Development Facilitation Team (DFT) – Review Comments

Project No: PR-2021-006261 Date: 06/28/2023 Agenda Item: #6&7 Zone Atlas Page: F-13
Legal Description: [TRACT 144-A-1, MRGCD MAP NO. 31, TRACT 144-B-2 OF MRGCD MAP 31, TRACT 2 OF THE BULK LAND PLAT OF TRACTS 1 AND 2, OUR LADY OF GUADALUPE]
Location: [PROPERTIES ADJACENT TO 1860 GRIEGOS ST. between THE GRIEGOS DRAIN and SAN ISIDRO]

Planning - Case Comments

Request: VACATION OF PRIVATE EASEMENTS & FINAL PLAT

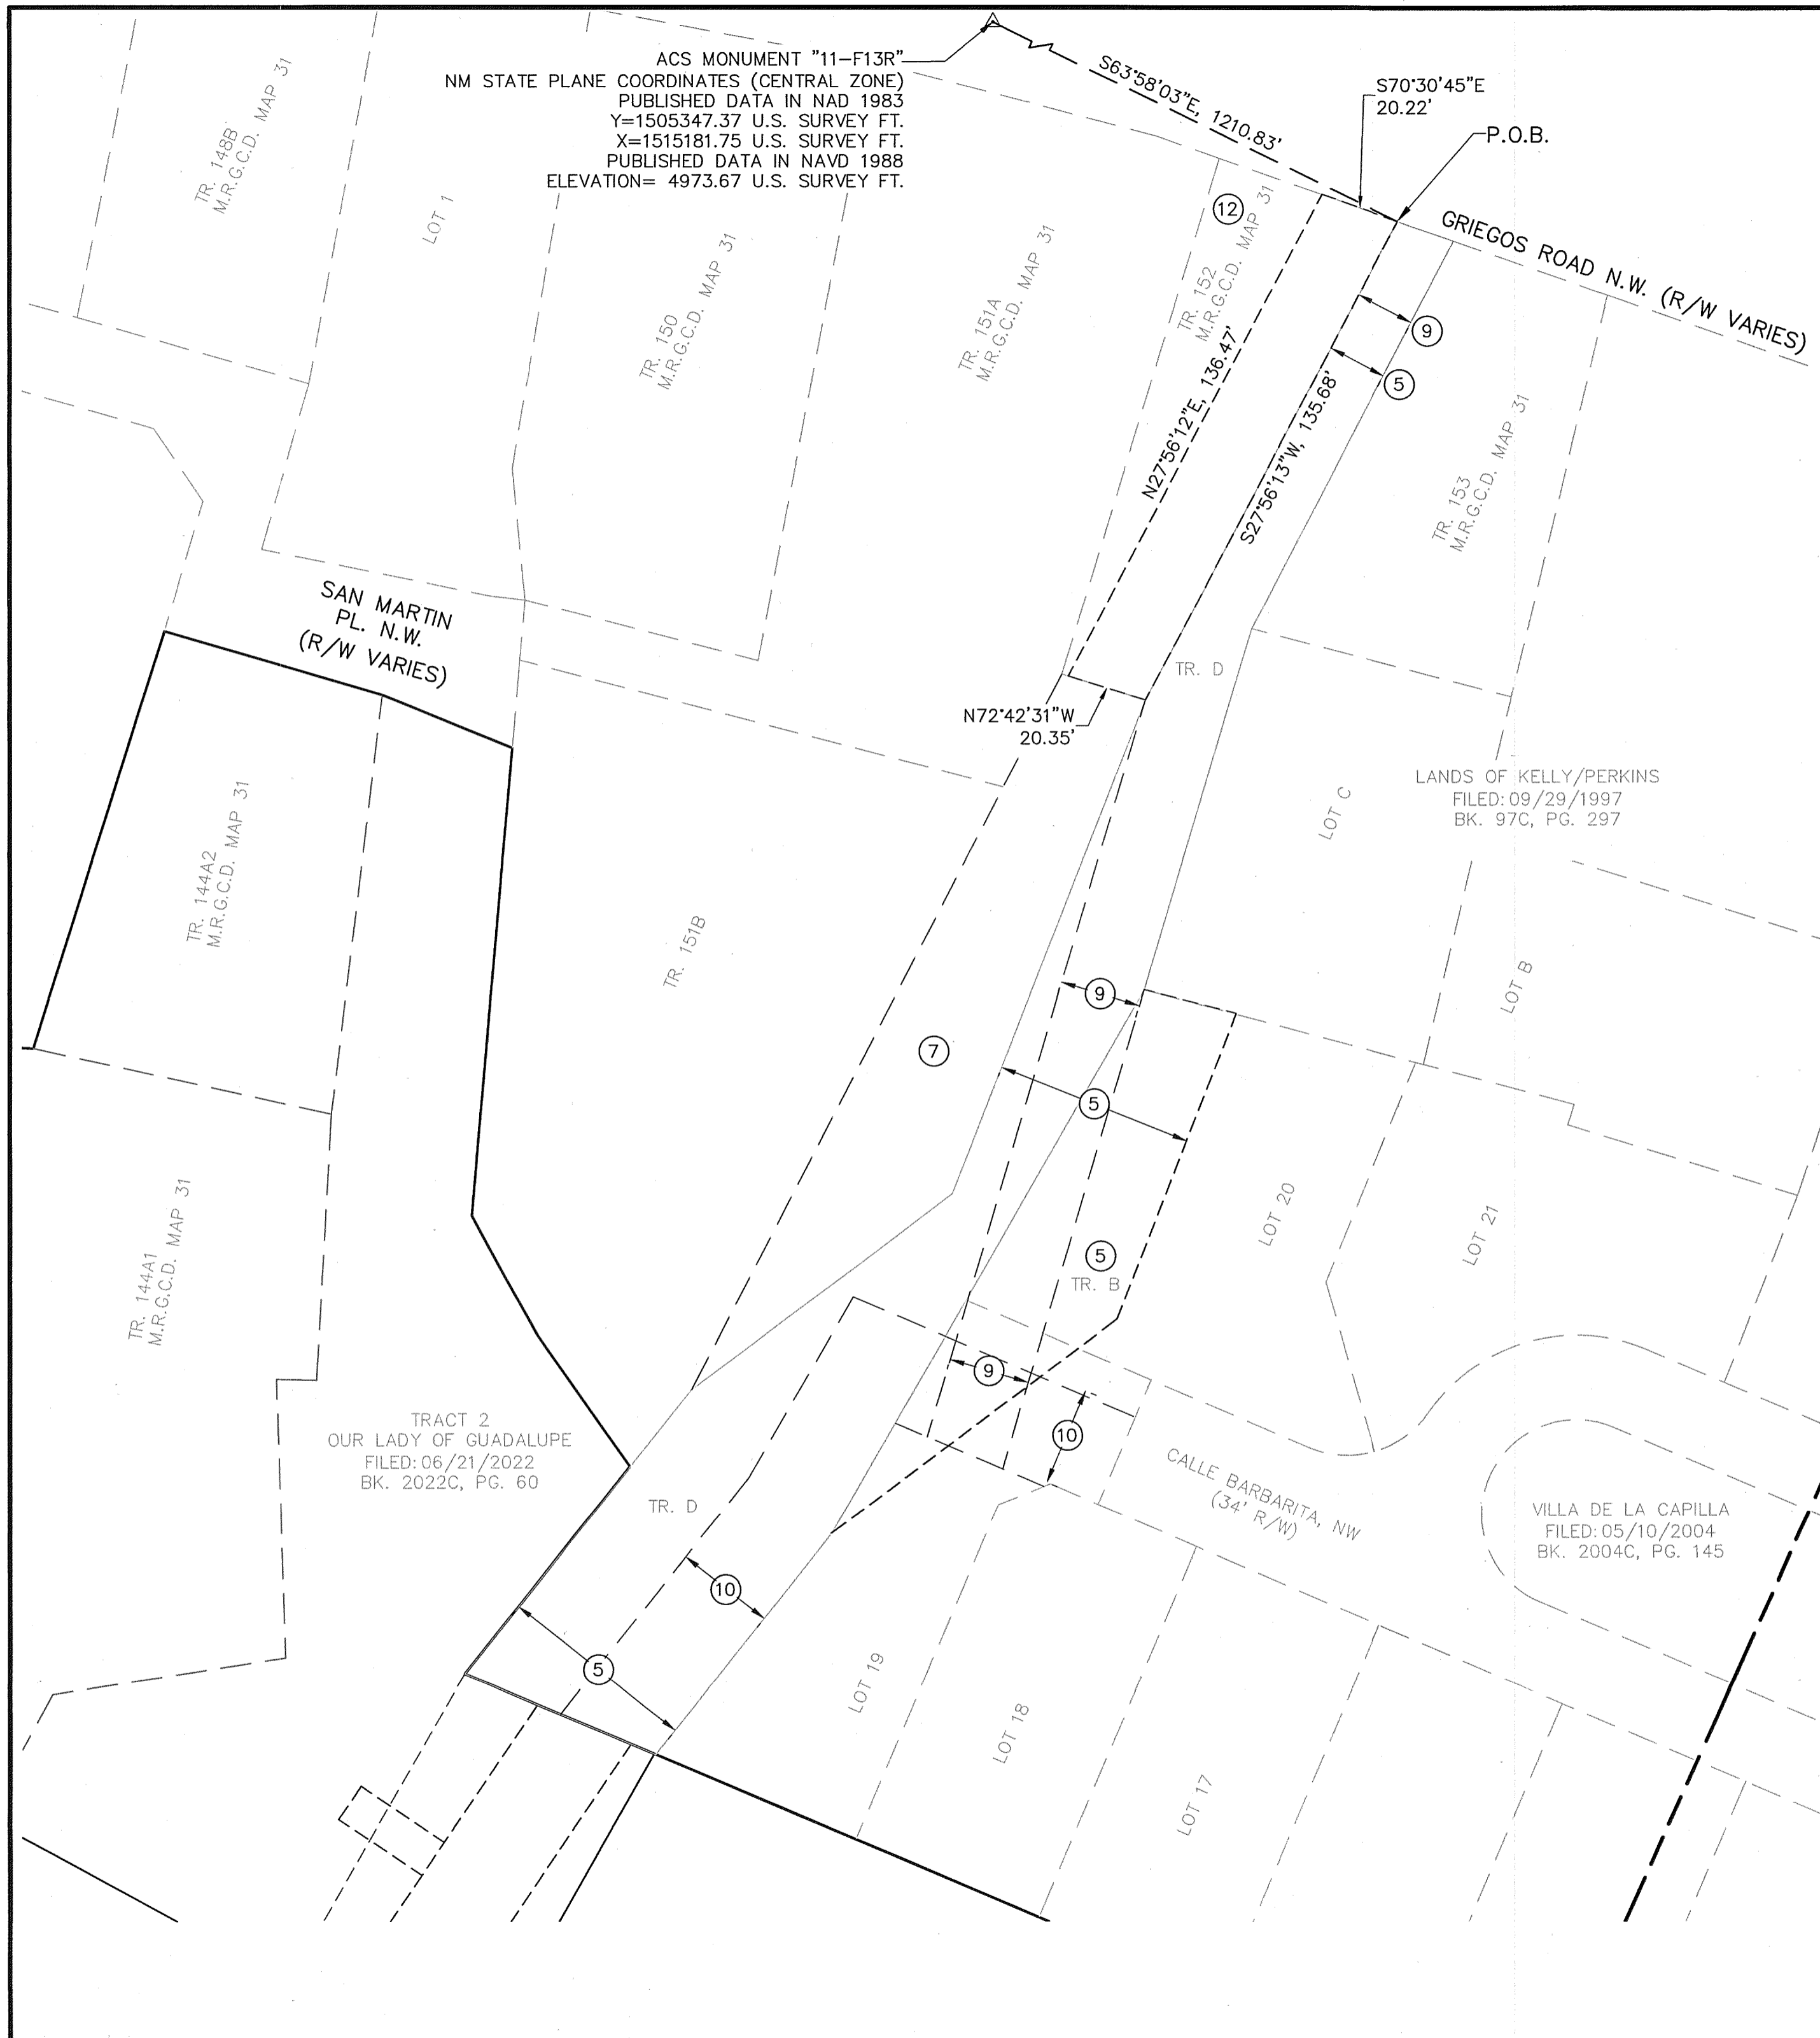
- **The Final Plat is not consistent with the Preliminary Plat** which was approved by the Development Review Board (DRB) on December 14, 2022. Per 6-6(L)(3)(b) of the IDO, a Final Plat shall be approved if it includes all changes, conditions, and requirements contained in the Preliminary Plat approval. However, the lot sizes of the Final Plat differ from those depicted in the DRB-approved Preliminary Plat. The table below compares the lot sizes in the Preliminary and Final Plat.

- Per 6-4(Y)(2) of the IDO, the proposed changes in lot sizes would require a Minor Amendment to the Preliminary Plat approval, which must be approved before the Final Plat can be approved by the DHO.

- The **Project number** needs (PR-2021-006261) to be added to the Plat. Also, the **Plat application number** must be added to the Plat as SD-2023-00105.

- The **signature block** needs to be corrected to the DHO signature block:
 - “City Engineer/Hydrology” signature block needs to be corrected to **“HYDROLOGY”**.

- “DRB Chairperson Planning Department” signature block needs to be corrected to **“PLANNING”**.
 - **“CITY ENGINEER”** signature block needs to be added as the last line for the signature block.

**EXISTING EASEMENTS**

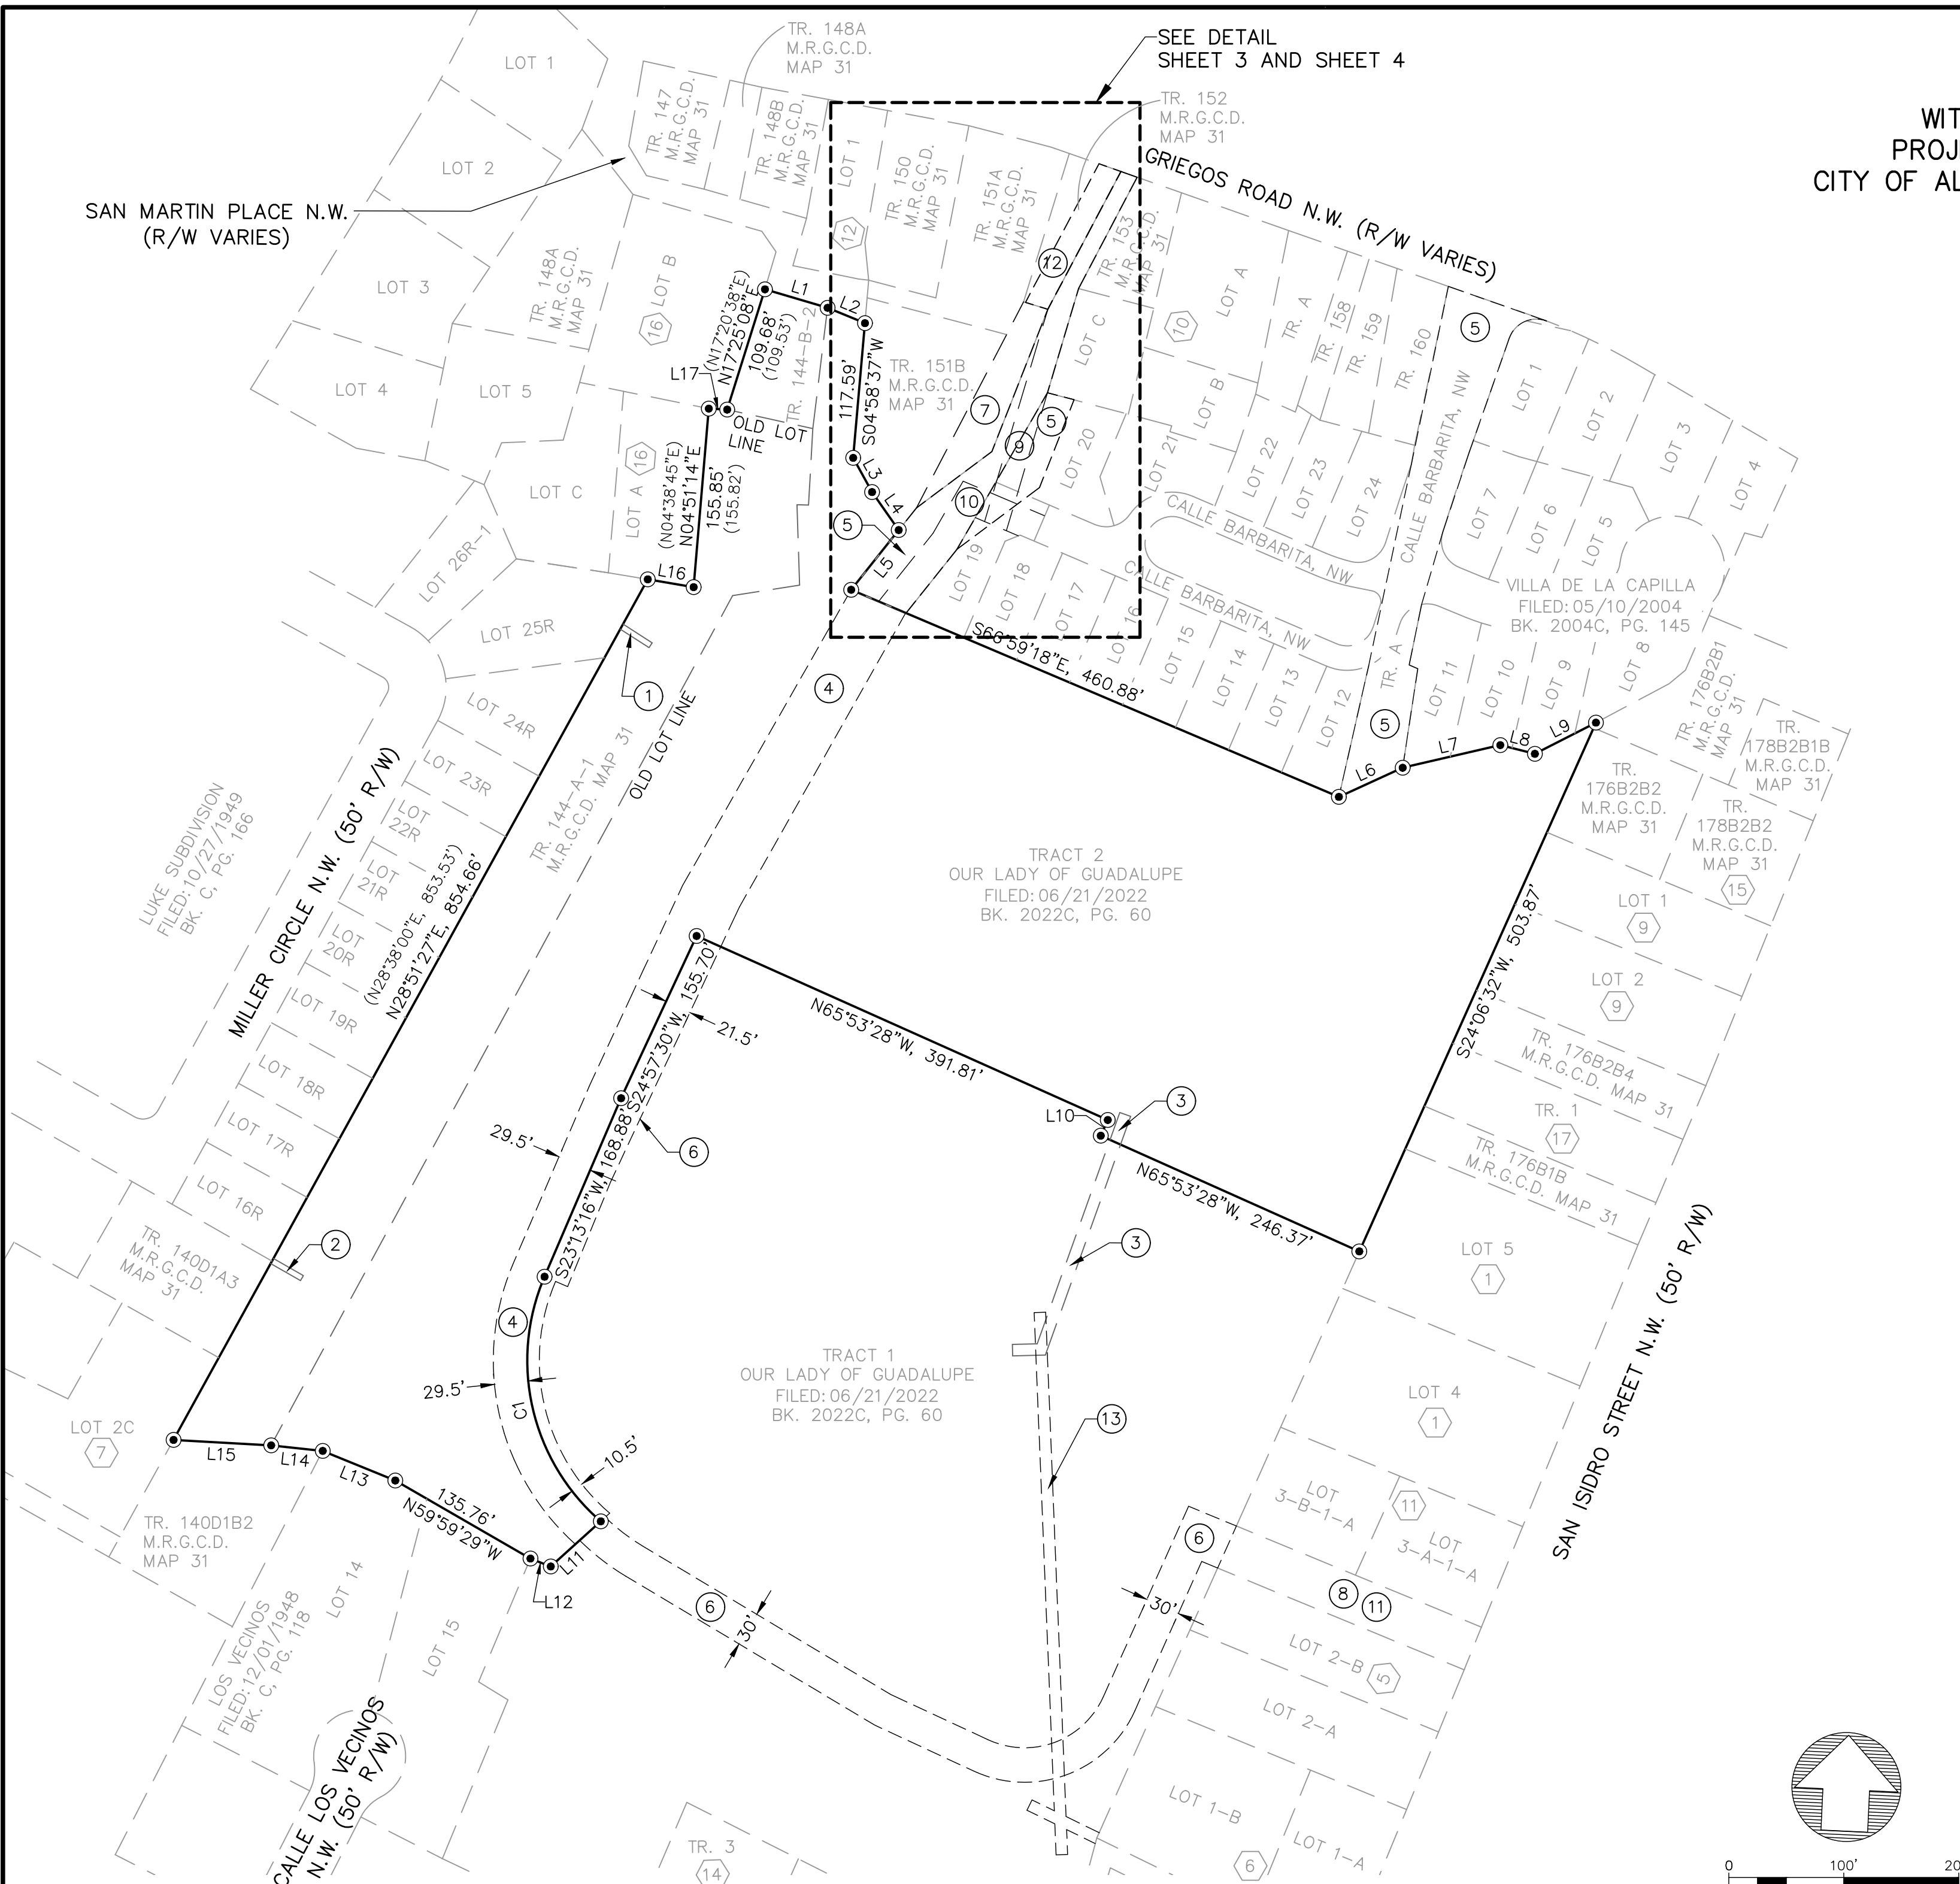
- The existing utility easement is listed as Number (1) on Sheet 6 of the Plat. This is a Utility easement. It is private, but there is a lack of documents to clarify if this guy wire is related to PNM, telecommunications, or other utility companies. **Staff requests the applicant confirm which utility companies this easement is/was occupied by.** The Applicant provided a justification letter for the vacation request for the easement pursuant to 14-16-6-6-(M)(3) of the IDO. **This letter needs to provide a specified reason or reasons why the existing easement impedes the proposed site plan layout, and how it will pose a safety risk for the tenants of the new development.**

- The existing utility easement is listed as Number (2) on Sheet 6 of the Plat. This is a Utility easement. It is private, but there is a lack of documents to clarify if this guy wire is related to PNM, Telephone, or other utility companies. **Staff requests the applicant confirm which utility companies this easement is/was occupied by.**

- The Applicant provided a justification letter for the vacation request for the easement pursuant to 14-16-6-6-(M)(3) of the IDO. **This letter needs to provide a specified reason or reasons why the existing easement impedes the proposed site plan layout, and how it will pose a safety risk for the tenants of the new development.**

- The applicant proposes to vacate an existing 10 feet easement of the Public Service Company of New Mexico and the Mountain States Telephone and Telegraph Company, recorded on April 30, 1967, Book Miscellaneous 364, Page 957, and listed as Number (3) on Sheet 6 of the Plat.
- **Please clarify which lot(s) this existing easement is located within.** Once clarification is provided about the location of the easement, staff will not object to the request, as the vacation was justified per 14-16-6-6-(M)(3) of the IDO.
